CLIENT/PROJECT: **MOUNTAIN VIEW ELECTRIC ASSOCIATION YODER SUBSTATION**

TITLE: **LANDSCAPE PLAN**

CASE ID# **EA-17-205**

SHEET: L-1
OF 1

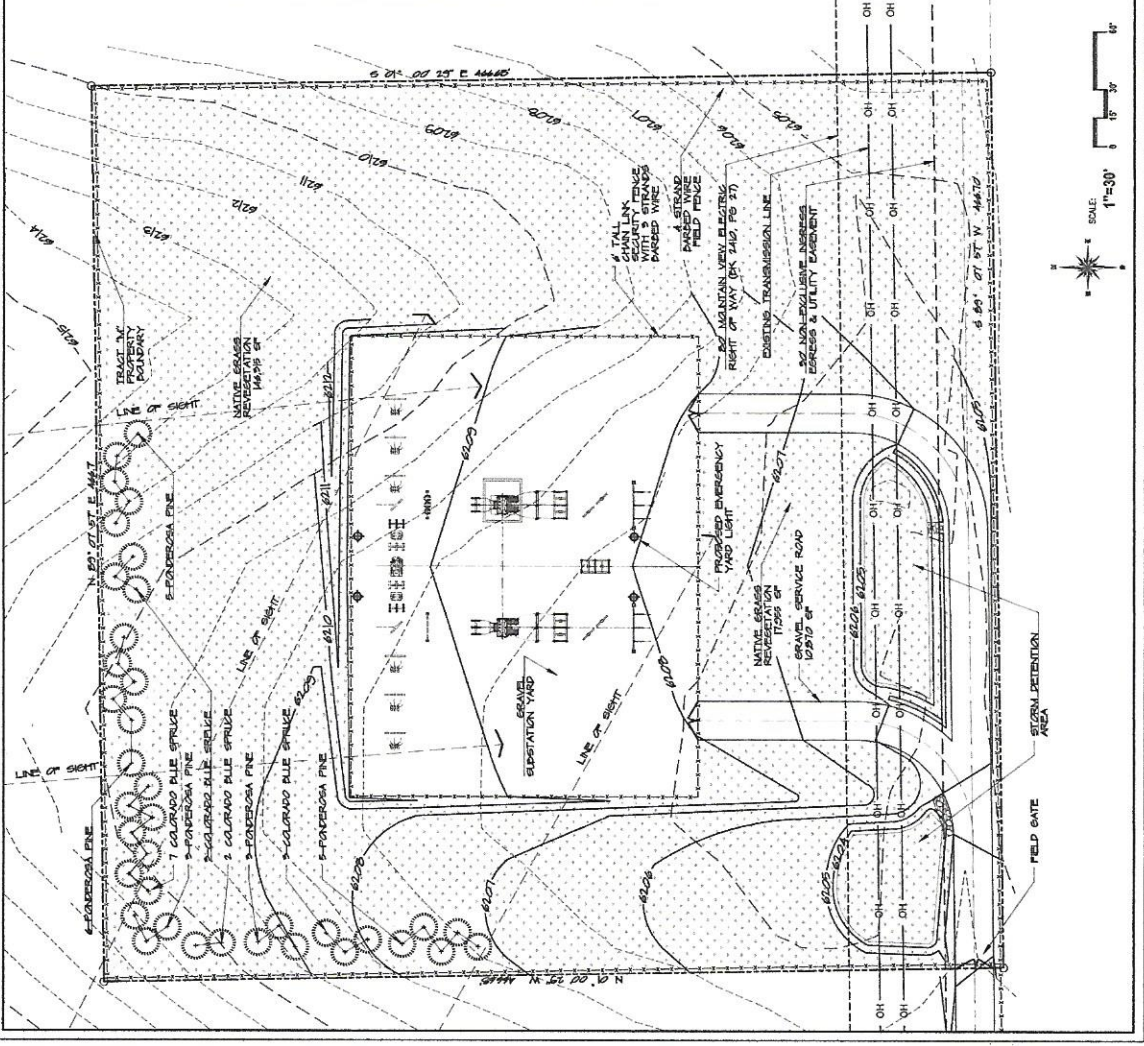
Please review 6.2.2(D)(b) of the Land Development Code for screening requirements. If an Alternative Landscape design is requested, it must be identified in the Letter of Intent.
